# SUNNICA ENERGY FARM

8.44 Applicant's Response to Local Impact Report – Response to  
Annex E and Annex F

<b>Version</b>	<b>Date</b>	<b>Status of Version</b>
Rev 00	28 November 2022	Deadline 3A Submission

Hedge Height
2-4m

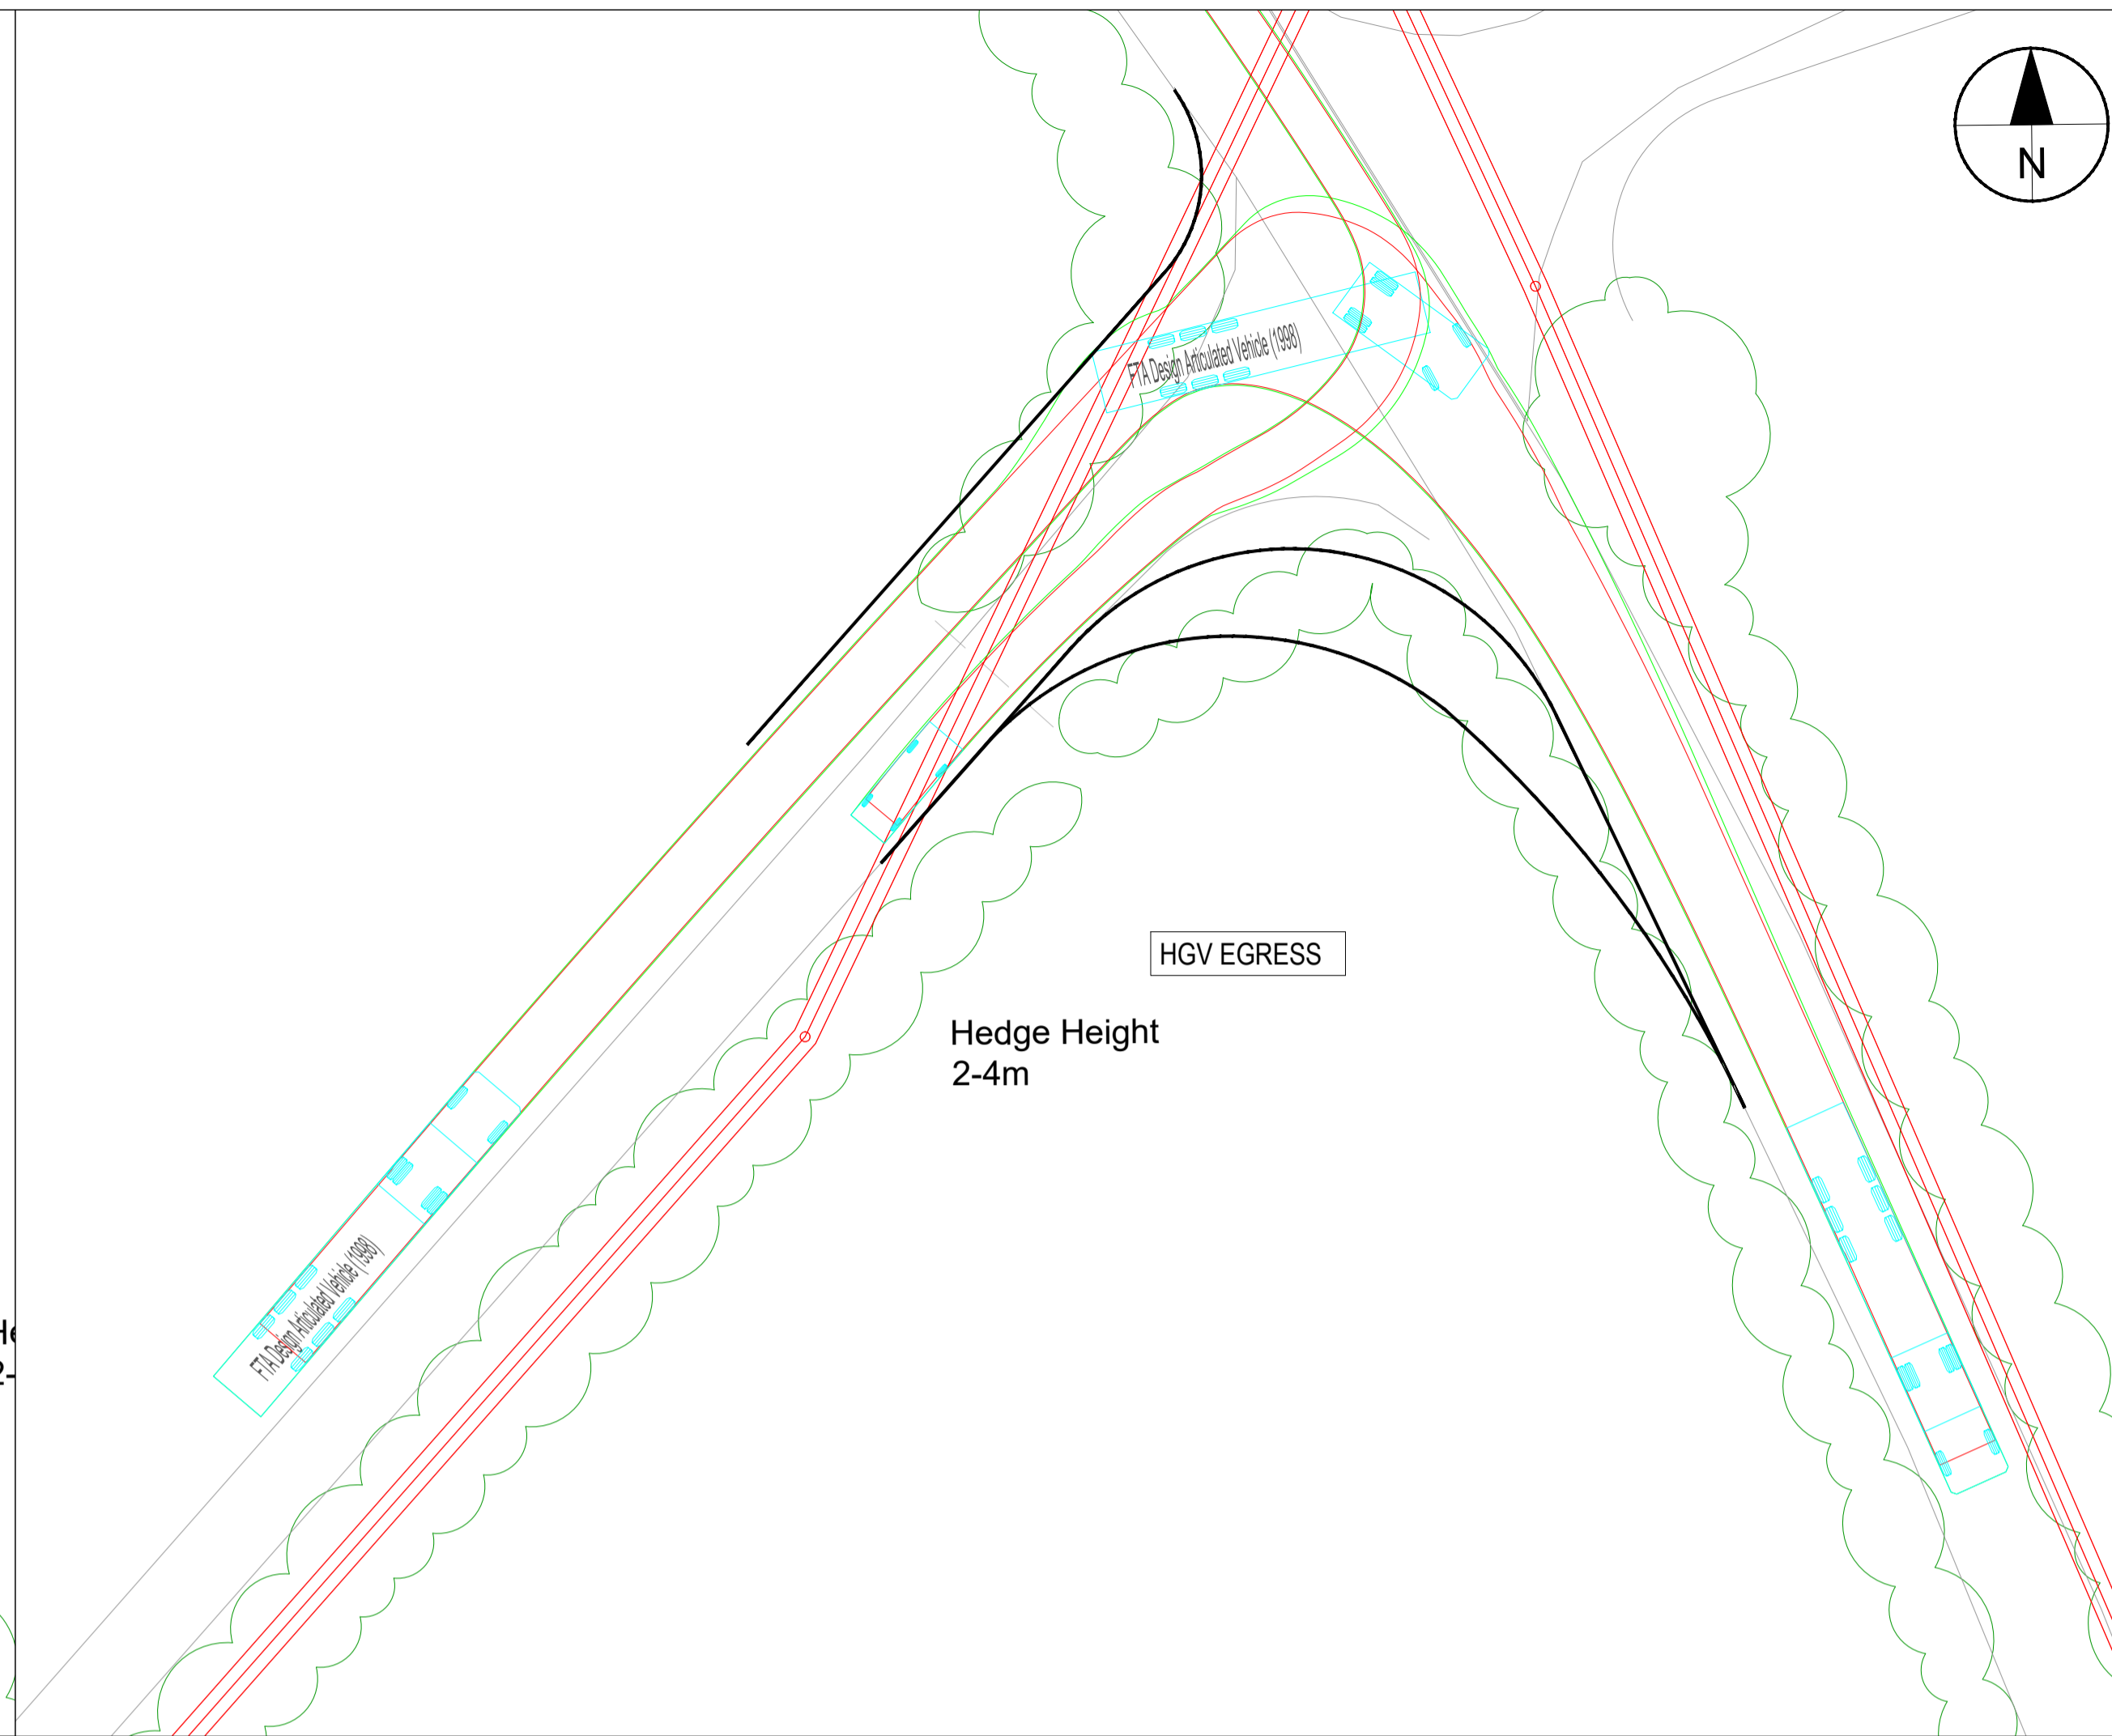
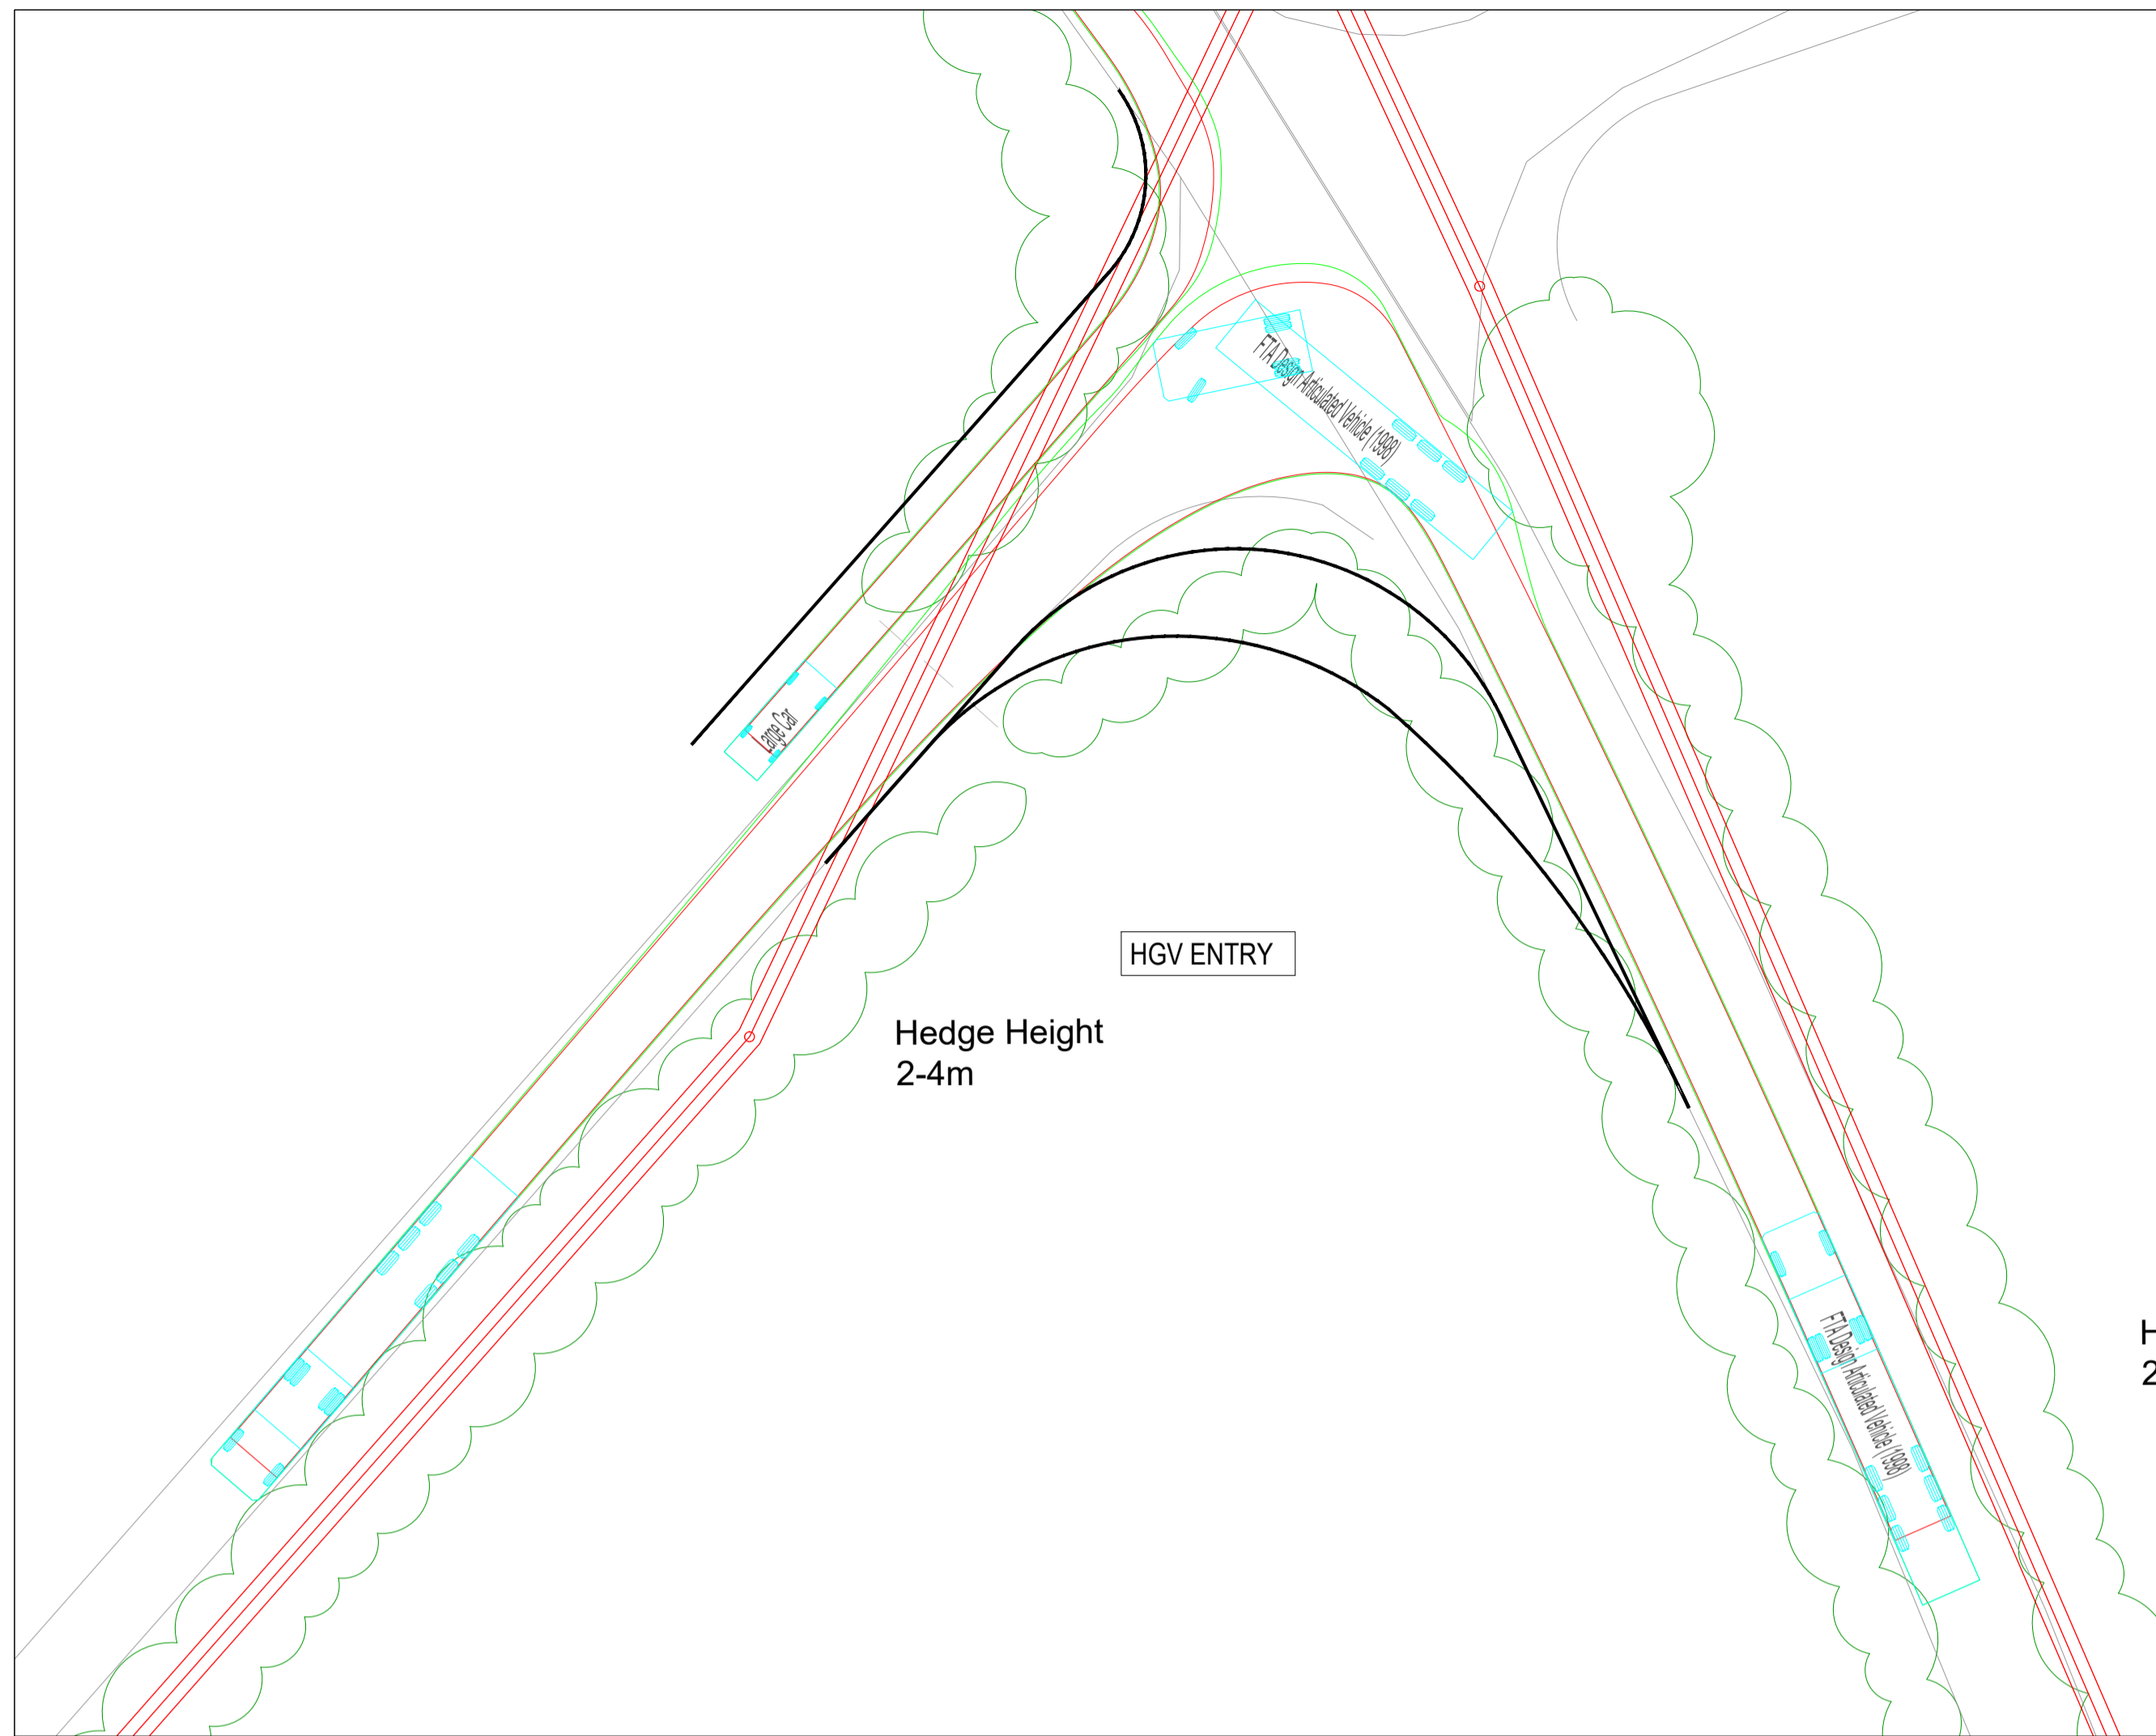
E.14-E.19	Comments on Individual Accesses Sunnica West Site A: Site Access A on La Hogue Road	<p>It should be noted that this access is in the location of an existing site access opposite the farm shop. The full visibility splay will be provided during the construction and operational phase of the scheme within the Order limits and is shown in the next iteration of the Framework Construction Traffic Management Plan and Travel Plan the Applicant submitted at Deadline 3A. The construction staff will arrive on site before 7am and leave site after 7pm, as per paragraph 7.2.26 in the Framework Construction Traffic Management and Travel Plan [REP3-013]. This is outside of the opening hours of the farm shop, and therefore there will be minimal interaction between traffic using the site access and traffic using the farm shop during the construction period.</p> <p>It is noted the comment made regarding the provision of the visibility splay on the loss of hedgerow. This has been assessed from a Landscape and Ecology perspective in the Environmental Statement [APP-40].</p> <p>As previously stated, the Applicant has noted comments from the LHAs regarding the information provided in the site access plans. A draft set of site access drawings has been prepared and provided to the LHAs. The set of drawings provided to the local highway</p>

LIR Summary Reference (Para)	Summary of LIR Comment	Applicant's Response to LIR
		<p>authorities are to be provided within the next iteration of the Framework Construction Traffic Management Plan and Travel Plan submitted at Deadline 3A. A further meeting was held on 24/11/22 to discuss each of the site access proposals with the outcomes of discussion intended to be reported within the relevant Statement of Common Ground.</p> <p>Other points in relation to design information are set out in response to Chapter 13 points 1g to 1w. The level of information available is proportional to the stage of the project with detailed design of the site accesses to be provided at a later stage, prior to construction. The detailed design of site accesses is required to be submitted for the approval of the relevant planning authority prior to the commencement of the project in accordance with requirement 6 contained in Schedule 2 to the draft DCO.</p> <p>The radius has been identified based on the swept path analysis of a 16.5m articulated HGV and a 46.63m AIL. Therefore, it is considered the radius to be appropriate for the purpose of use. The radius to the north of the junction is not proposed to be modified as large vehicles will not be required to access from the north of La Hogue Road as this is not on the HGV route identified within, and secured by, the Framework Construction Traffic Management Plan and Travel Plan [AS-300, AS-301].</p> <p>The swept path analysis of two-way vehicle movement at the staff car parks is provided in the iteration of the Framework Construction Traffic Management Plan and Travel Plan the Applicant proposes to submit at Deadline 3A.</p>
